File ref. no: BFS19/1193  
Doc. ref. no: D19/29770  
Contact: Qualified Firefighter Nathan Everett

**Notice of Exhibition  
Lane Cove West Data Centre (SSD 9741)  
1 Sirius Road, Lane Cove (Lane Cove LGA)**

It is understood that the Notice is in regard to a proposed data centre at Lane Cove West. An Environmental Impact Statement report (the Report) including accompanying appendices has been prepared in support of the application.

MASTER PLAN - HYDRANT POINT

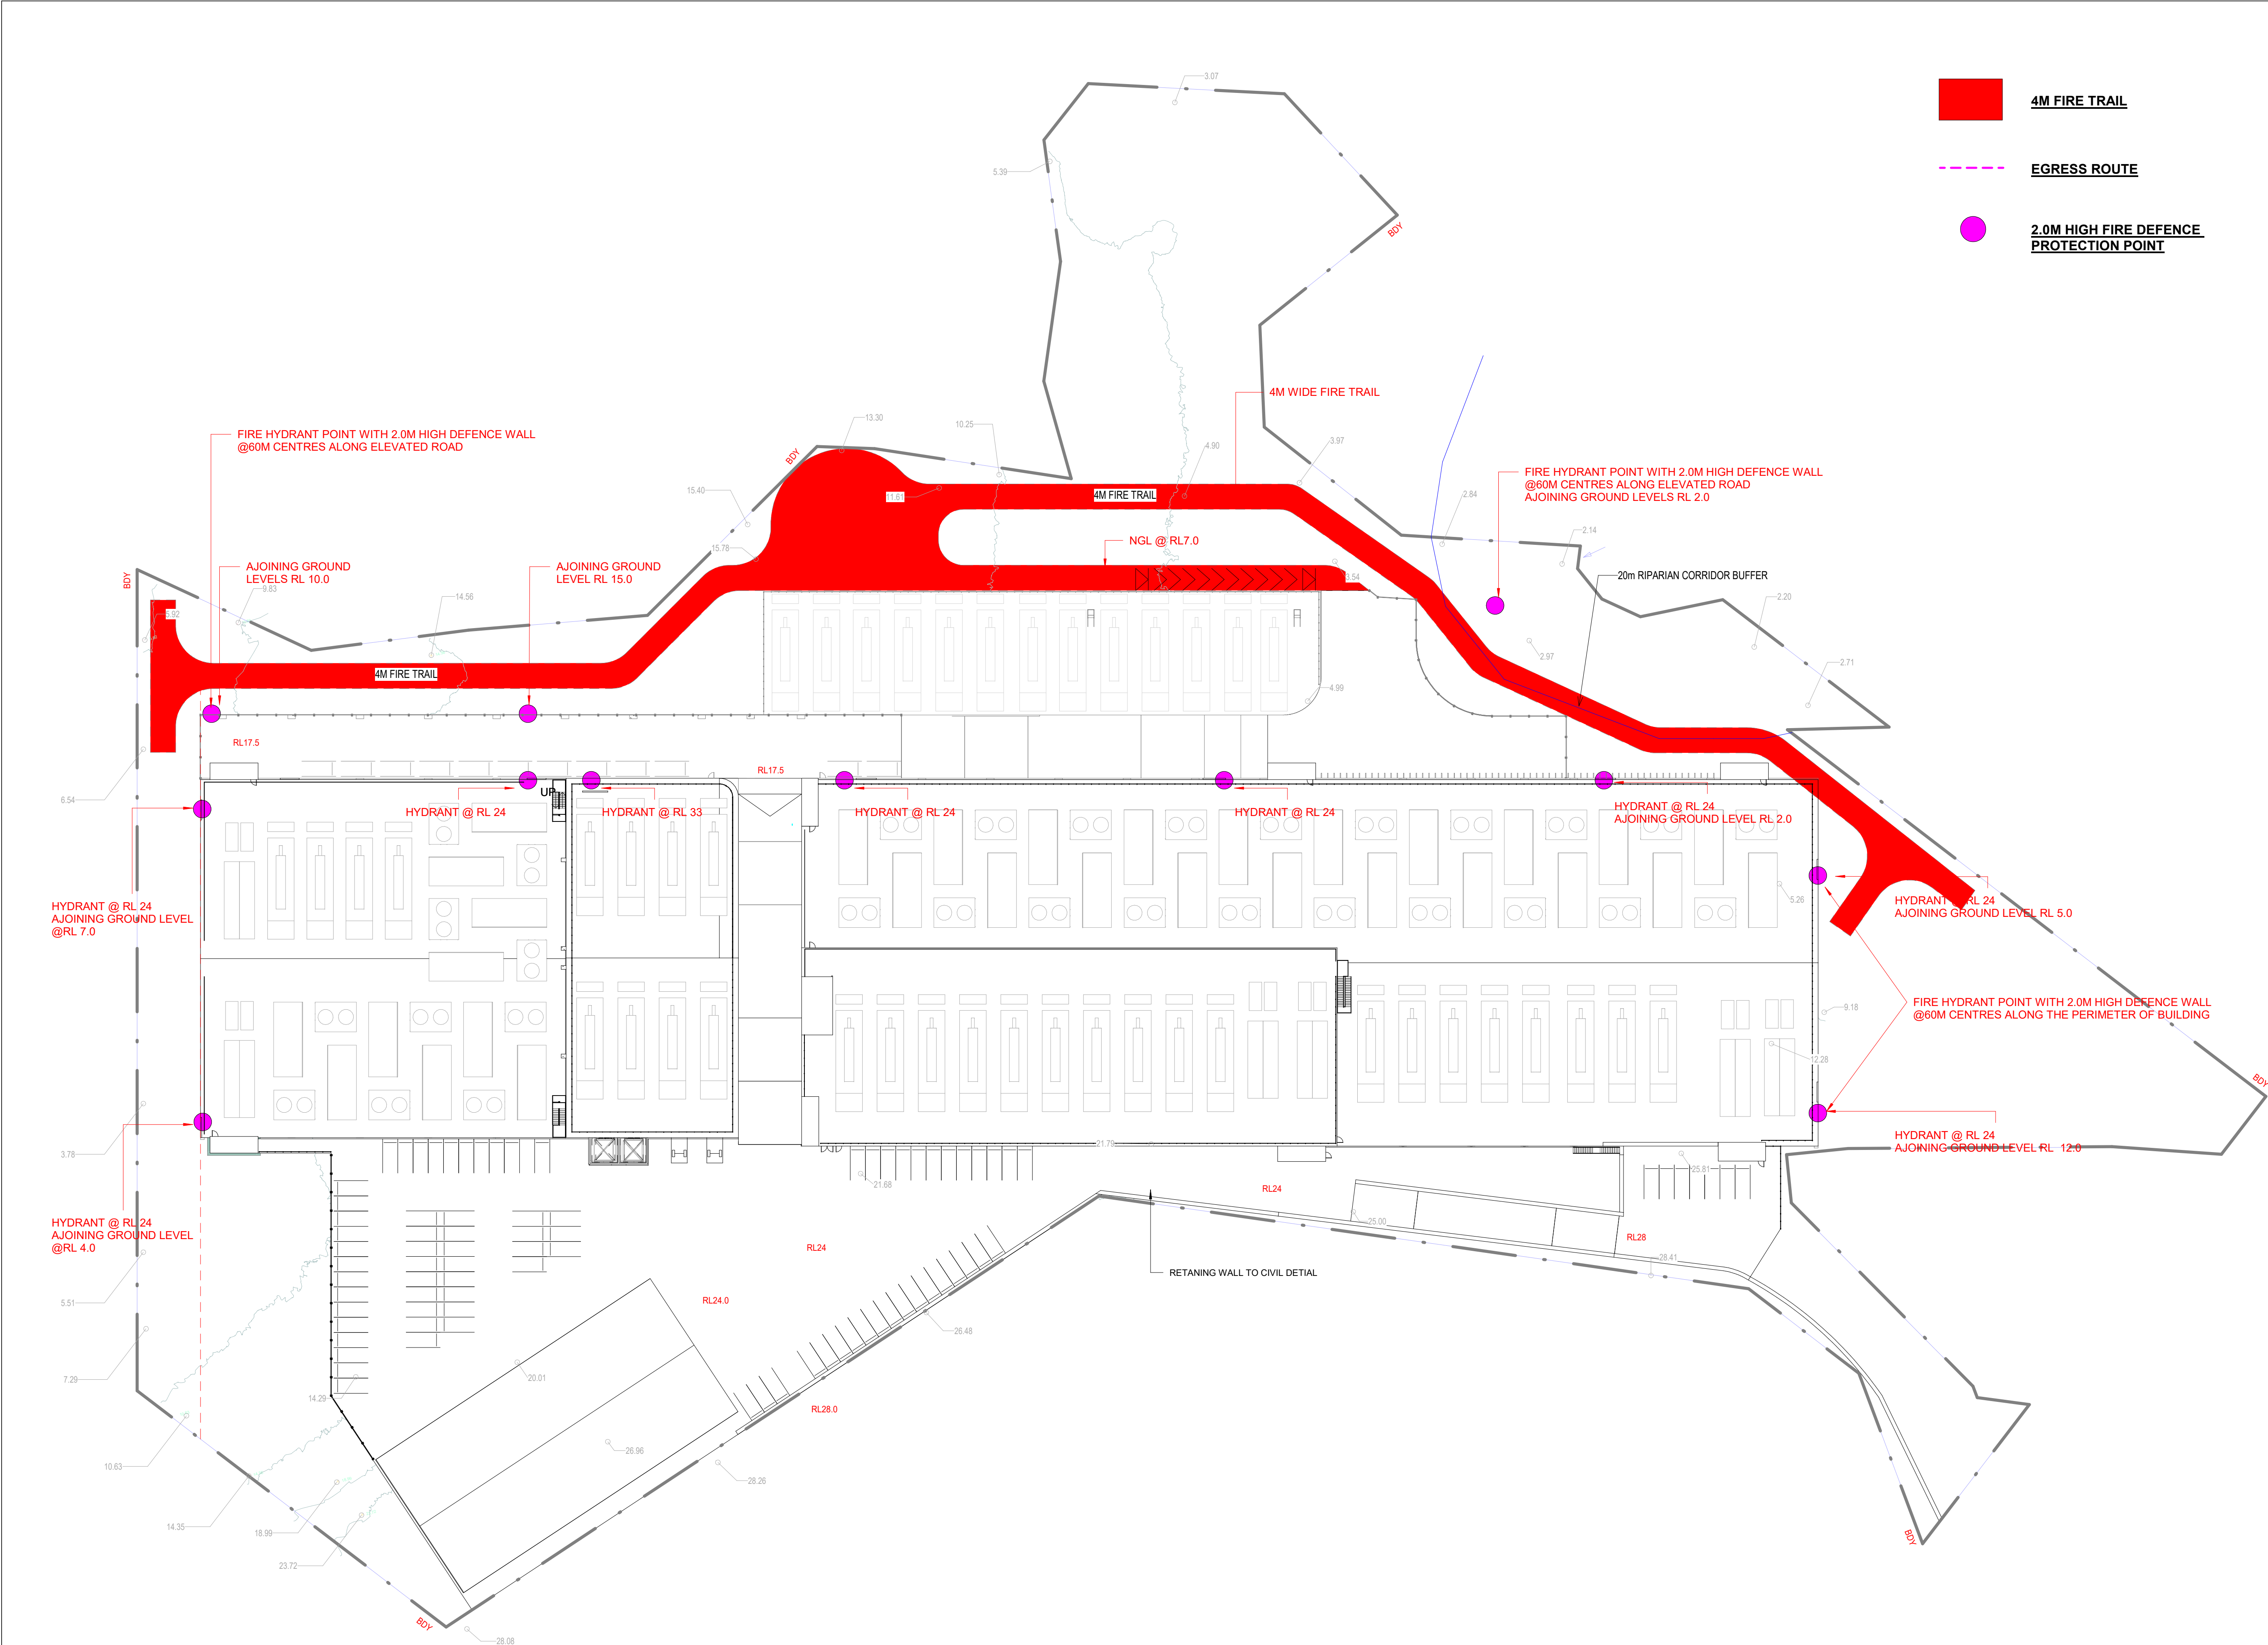
- Confirmation should be provided that no flammable liquids will be stored with the diesel such that it would be treated as a class 3PGIII dangerous good in accordance with SEPP 33.
- Consultation with FRNSW be undertaken by way of the Fire Engineering Brief Questionnaire (FEBQ) process prior to the issue of the relevant construction certificate.
- Further information be provided in regard to the storage of the diesel on site, including consideration and provisions made for special problems of fighting fire in accordance with E1.10 of the National Construction Code (NCC).
